Current Zoning: N1-B (Neighborhood 1-B)
Proposed Zoning: N1-F(CD) (Neighborhood 1-F, conditional)

Approximately 1.99 acres located along the north side of Tom Hunter Road, west of Hidden Forest Drive, and south of I-85.

The petition proposes to allow a multi-dwelling development on a parcel currently developed with one single family detached home.

**STAFF
RECOMMENDATION**

REZONING SITE PLAN

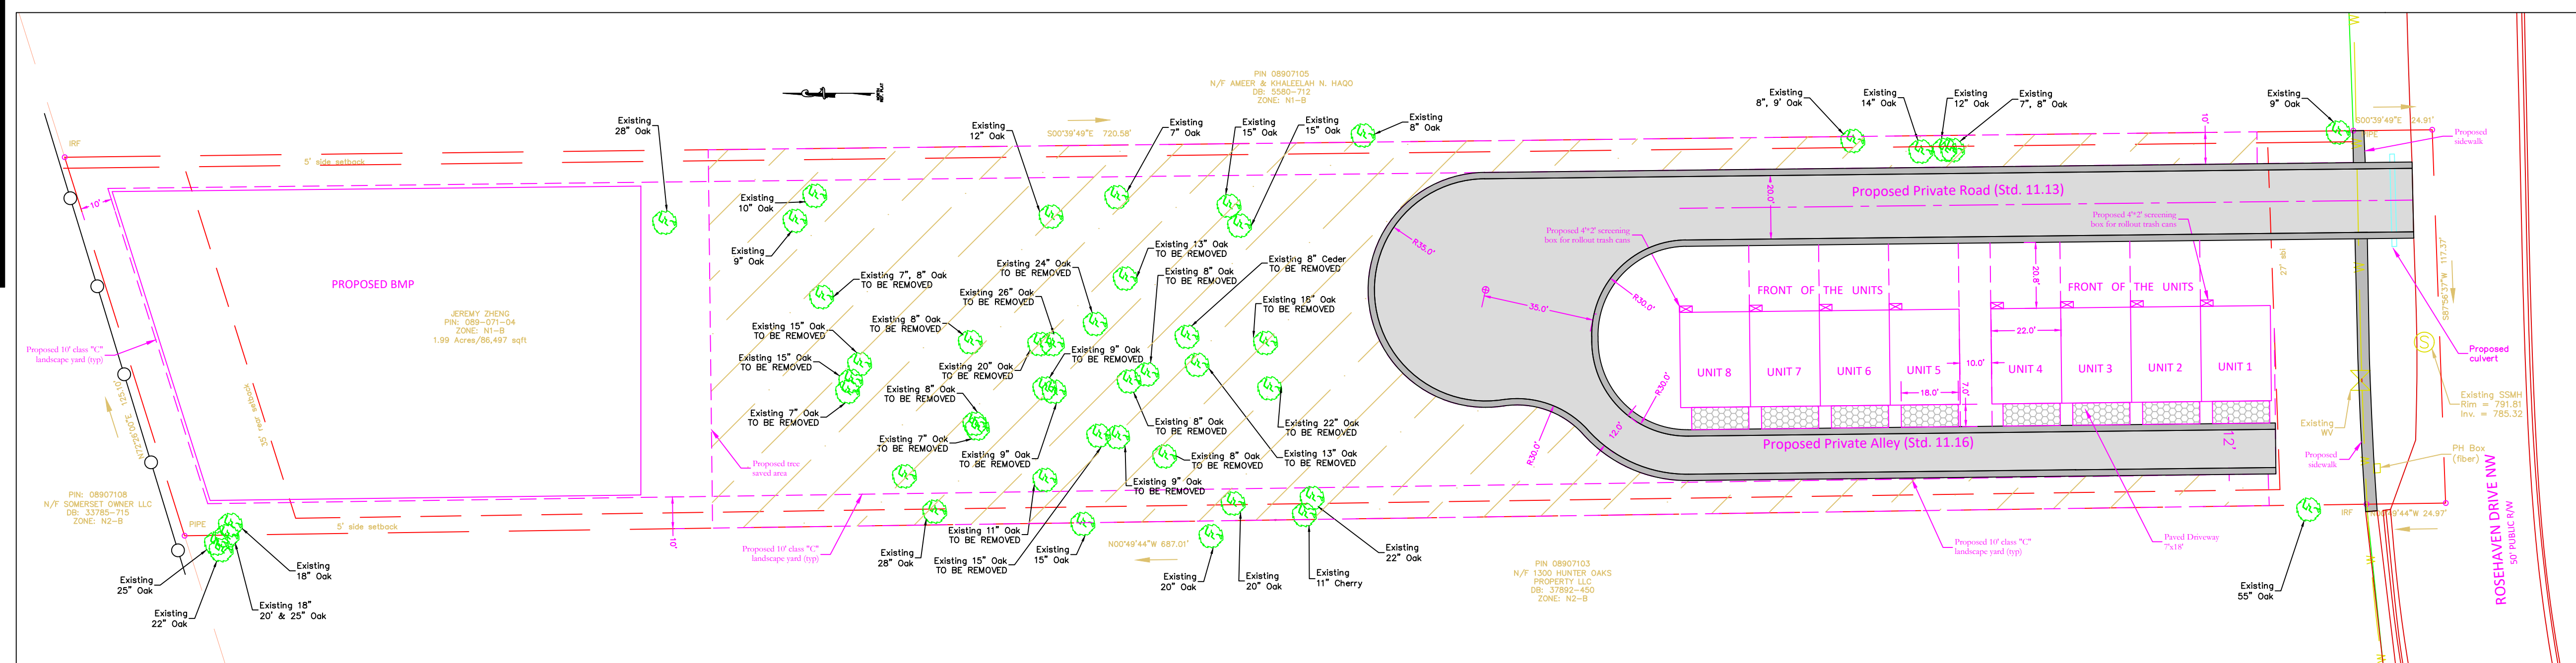
1. ~~Label and dimension curb and gutter from the centerline. Revise the site plan and conditional notes to commit to constructing bicycle facilities by locating the curb and gutter 24' from roadway centerline.~~
Addressed
2. ~~Adjust the Proposed ROW to 42.5 feet, which places the ROW at the back of the proposed sidewalk.~~
Addressed
3. ~~Revise site plan and conditional note(s) to commit to providing cross access to adjacent parcels per UDO chapter 31-2. Add a label to the site plan calling out cross access location.~~ **Addressed**

4. ~~Clearly label internal sidewalks connecting units to the internal private street and Tom Hunter Road.~~
5. ~~Provide notes on if and how common open space areas might be amenitized.~~ **Addressed**

6. ~~Confirm in the conditional notes on which portions of the rezoning boundary the landscape yard is proposed.~~ **Addressed**
7. ~~Modify the data development table so that the rear yard reads as "rear setback" and clarify that the rear setback required is 20' and what is being proposed is 35'. Clarify in the data development table that the maximum building height allowed is 48' but 40' is being proposed, and remove reference to~~

- number of stories of the proposed building. Remove in the data development table references to the number of bedrooms and the design of the garages. **Addressed**
8. ~~The "site data" section is redundant and can be removed. **Addressed**~~
9. ~~Move the urban design standards notes to the architectural standards section. Note six of the urban design standards regarding unit count can be removed as the plan commits to four units per building. **Addressed**~~

10. ~~Combine the transportation notes into one section. **Addressed**~~

11. ~~Modify wording under the permitted uses to remove references to "single family attached" to be consistent with the UDO. The wording should read as eight attached units within a multi-dwelling development. **Addressed**~~

12. ~~Update the ROW dimension label on the site plan to 24' from the back of sidewalk. **Addressed**~~
